November 15, 2021

REF: Structural Inspection Pier Projection  
Tifane & Randy Chambers  
200 Gilchrist Rd  
Cameron, NC 28326  
Chuck Smith, Contractor

# DESIGN PROFESSIONAL INSPECTION FORM

CONCRETE BLOCK PIER DETAIL  
NOT TO SCALE

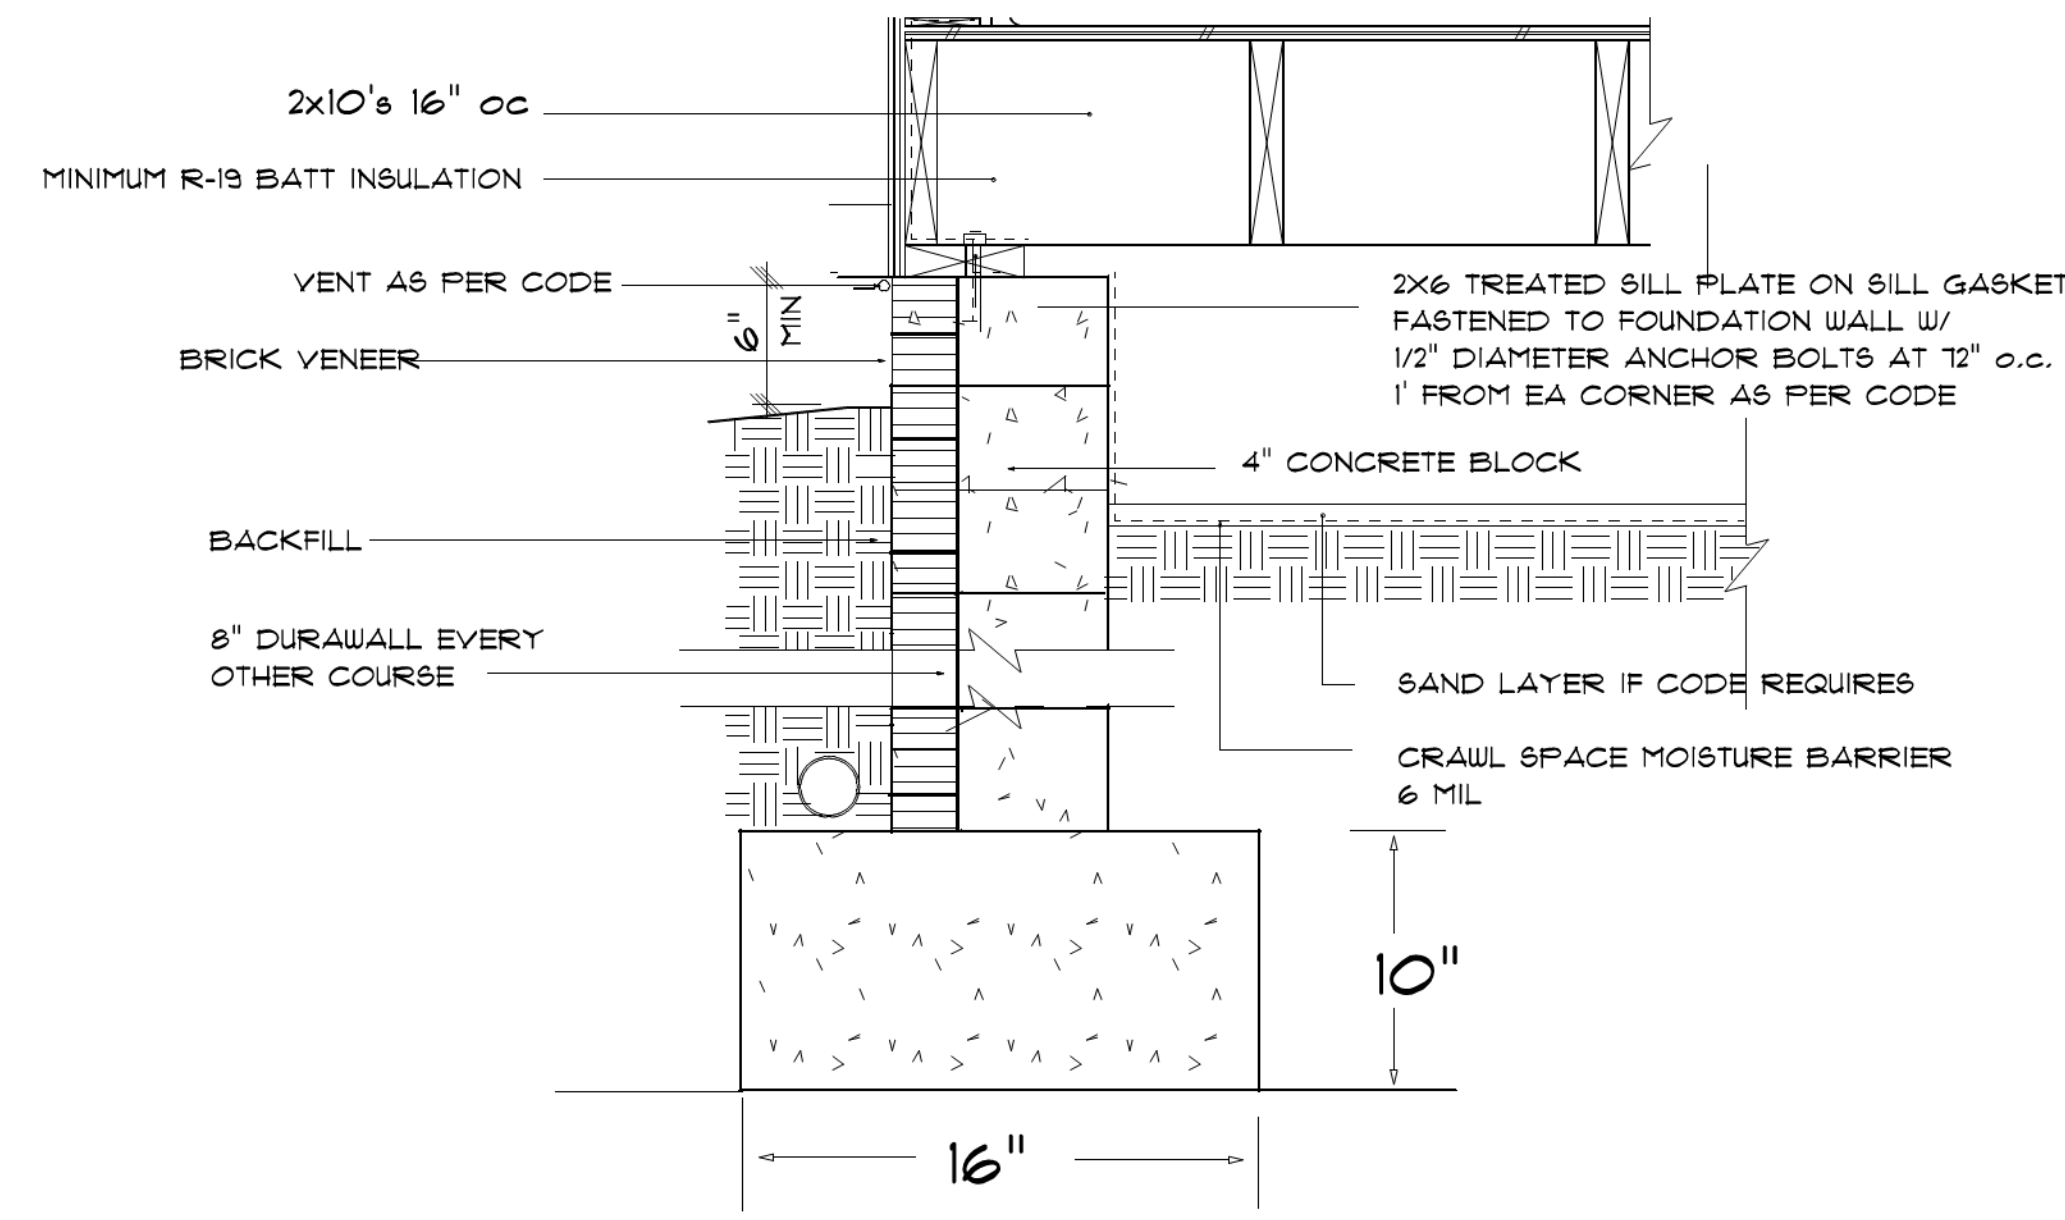
I made an onsite visit to the above referenced Residential site during November . 2021.. The purpose of the visit was to examine the reported lack of projection on piers and the front foundation wall. Although the actual projections did not meet code requirement, there was some projection at all of the piers and wall. I recommended that the Contractor place additional concrete at the footings with the inadequate projection to provide lateral support at these areas. With the placement of the concrete completed, I approve the piers & footings.

The piers & footings will support the live and dead loads as specified in the North Carolina Residential Building Code, 2018,ed.
